## REQUEST

Current Zoning: UR-C(CD) (urban residential-commercial, conditional) and ML-2 (manufacturing and logistics-2)  
Proposed Zoning: UR-C(CD) SPA (urban residential-commercial, conditional, site plan amendment)

Approximately 1.32 acres located along the west side of Seigle Avenue and east side of Van Every Street, south of Belmont Avenue.

The petition proposes to amend an approved replan to modify the rezoning boundary, reduce the number of residential units, increase non-residential square footage, establish a project phase line, removes language pertaining to the 100-foot rail corridor, and add language pertaining to surface water management.

Skyline Townes
Rezoning Site Plan
 955 Seigle Avenue Charlotte, North Carolina

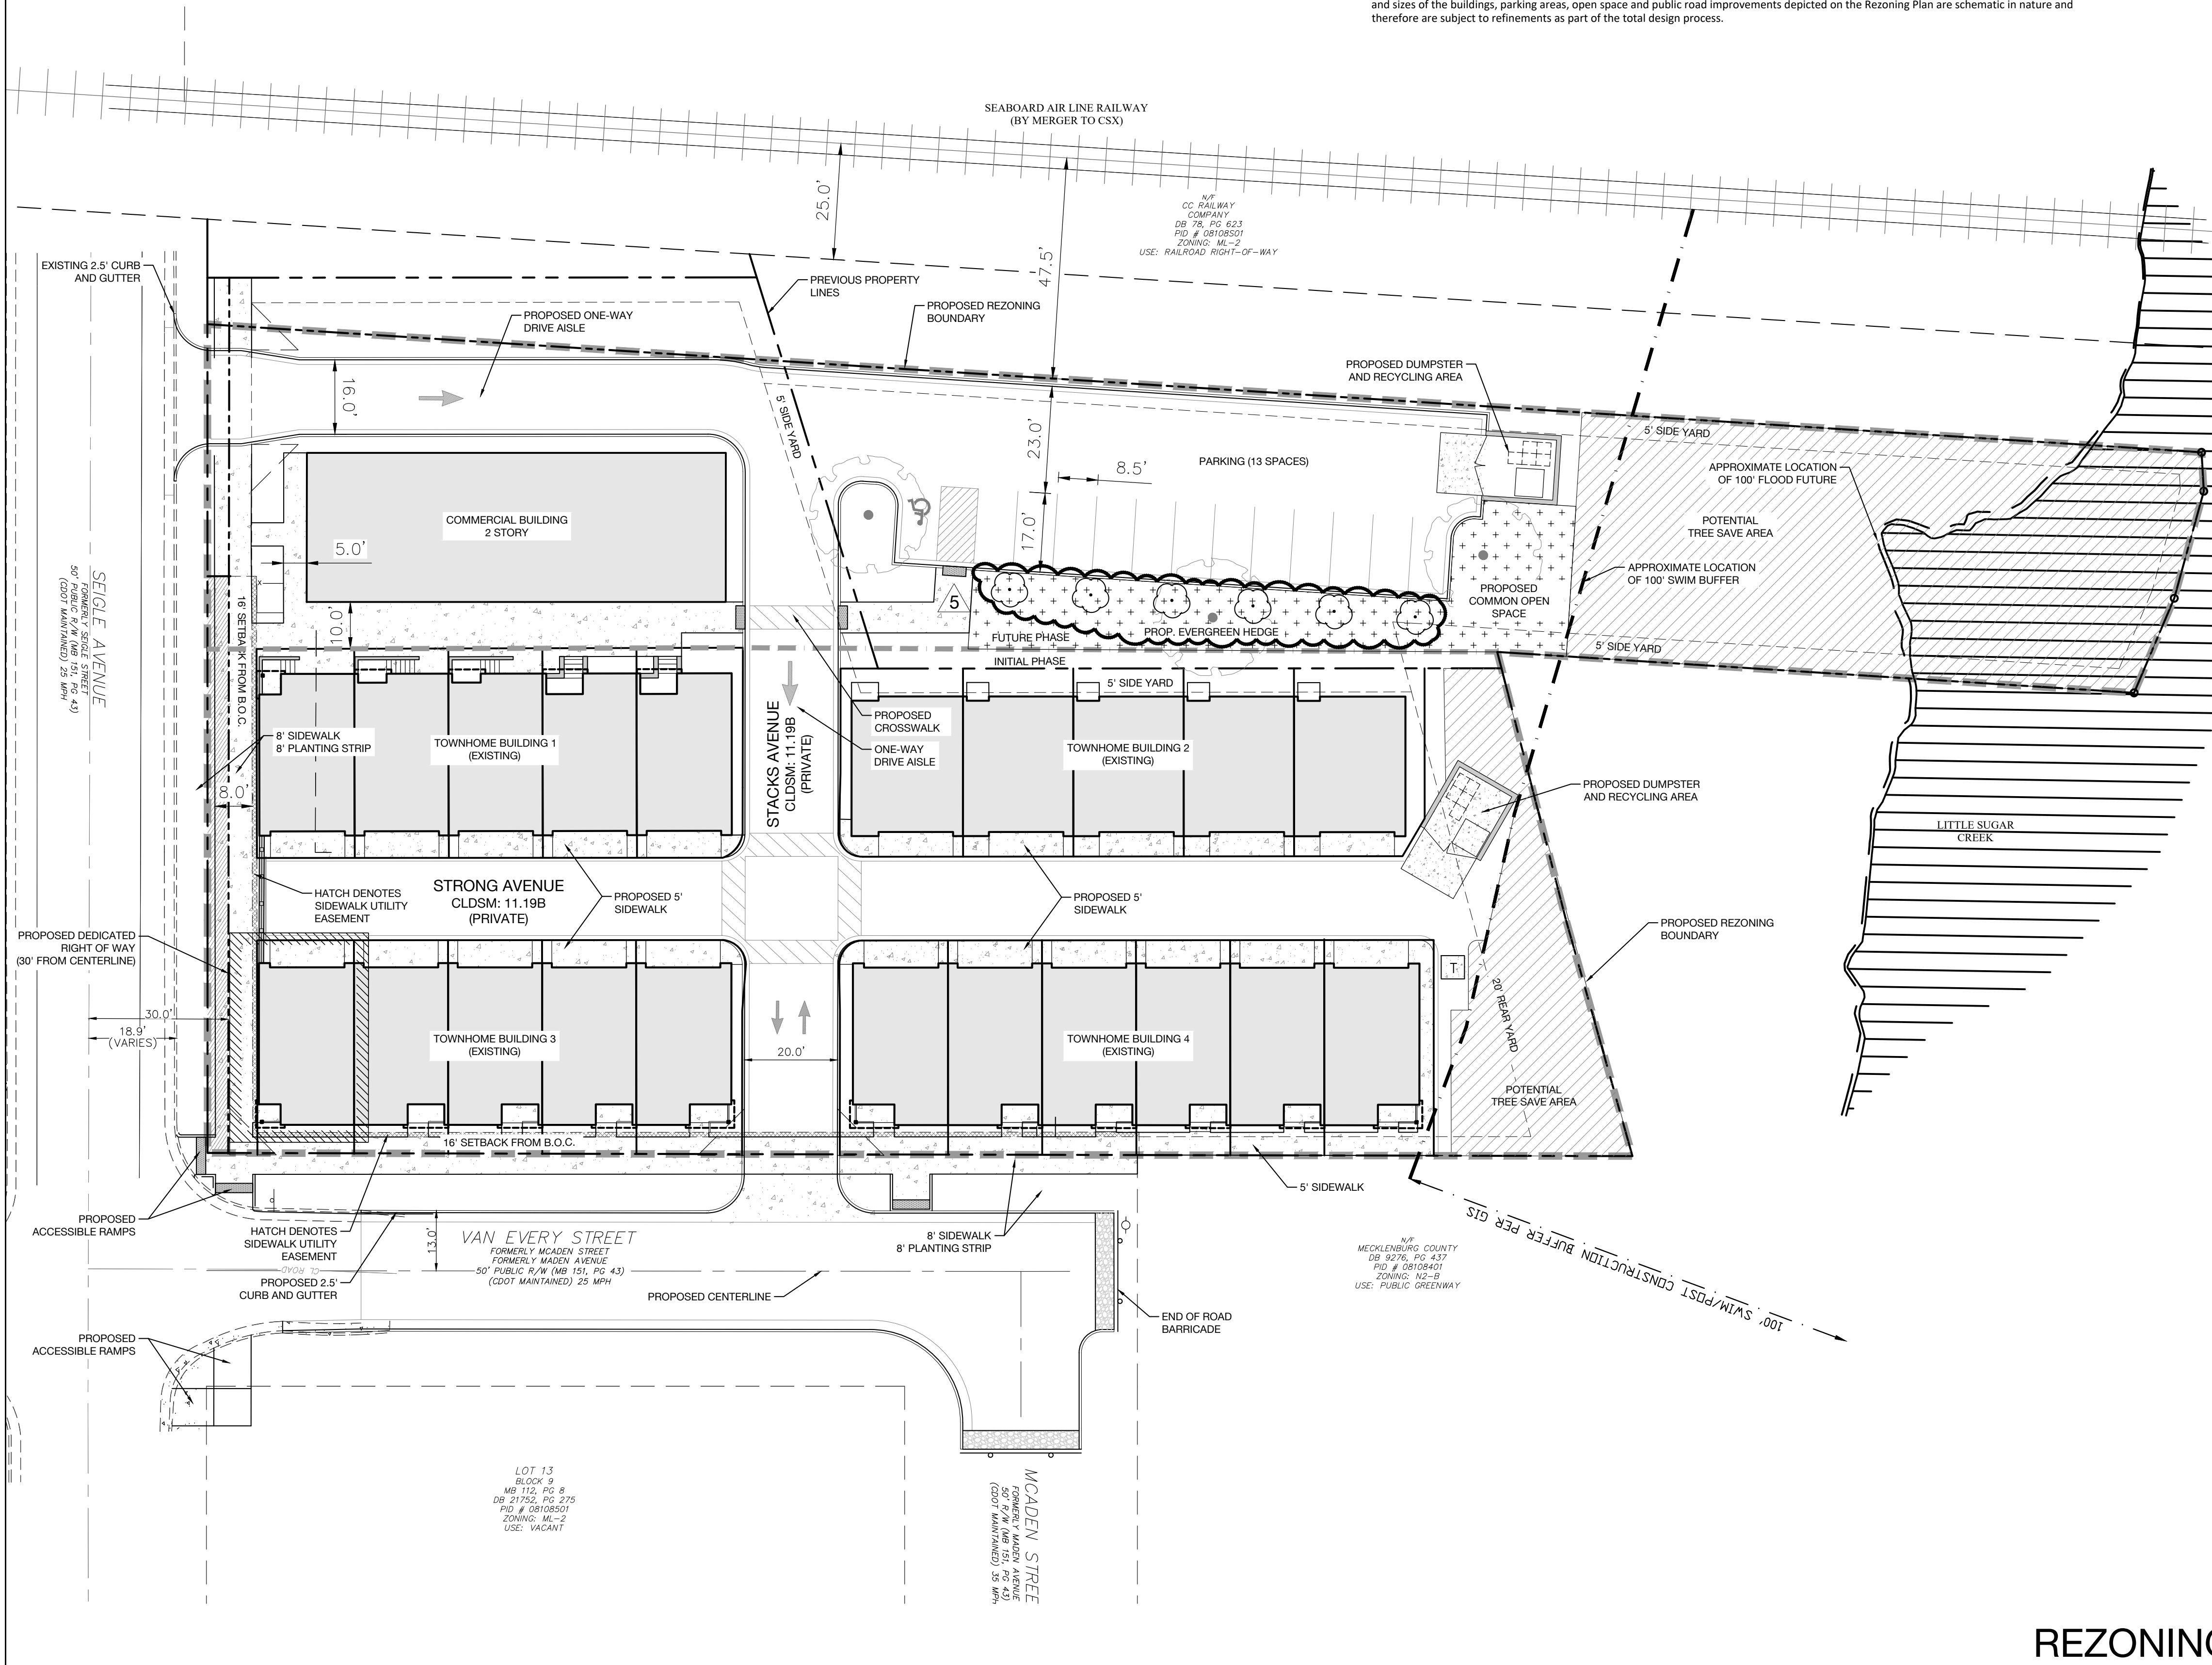
- **Mecklenburg County Parks and Recreation Department:** No outstanding issues.
- **Stormwater Services Land Development Engineering:** Buffer is to be measured from field-located top of bank of stream, not as shown on GIS. Please verify. See advisory comments at [www.rezoning.org](http://www.rezoning.org)

1. There is a discrepancy on the site plan with regard to acreage. Site Development Data specifies 1.32 acres while General Provisions Note 1 specifies 1.27 acres.
2. Parking lots for more than 10 automotive vehicles and parking decks, excluding new and used automotive sales lots and parking areas for detached, duplex, triplex or quadraplex dwellings on a single lot; (Ref. Sec. 12.303). This will be applicable to parking area abutting railroad right-of-way. In addition, petitioner should consider screening commercial parking area from residential units.
3. Please confirm vicinity map matches rezoning boundary modification.
4. Please confirm Architectural and Design Standards Note 3.a as Permitted Uses Note 1.a states the existing building will be demolished.

5. Show tree save calculations. Any tree save that is being replanted must be done at 150%.
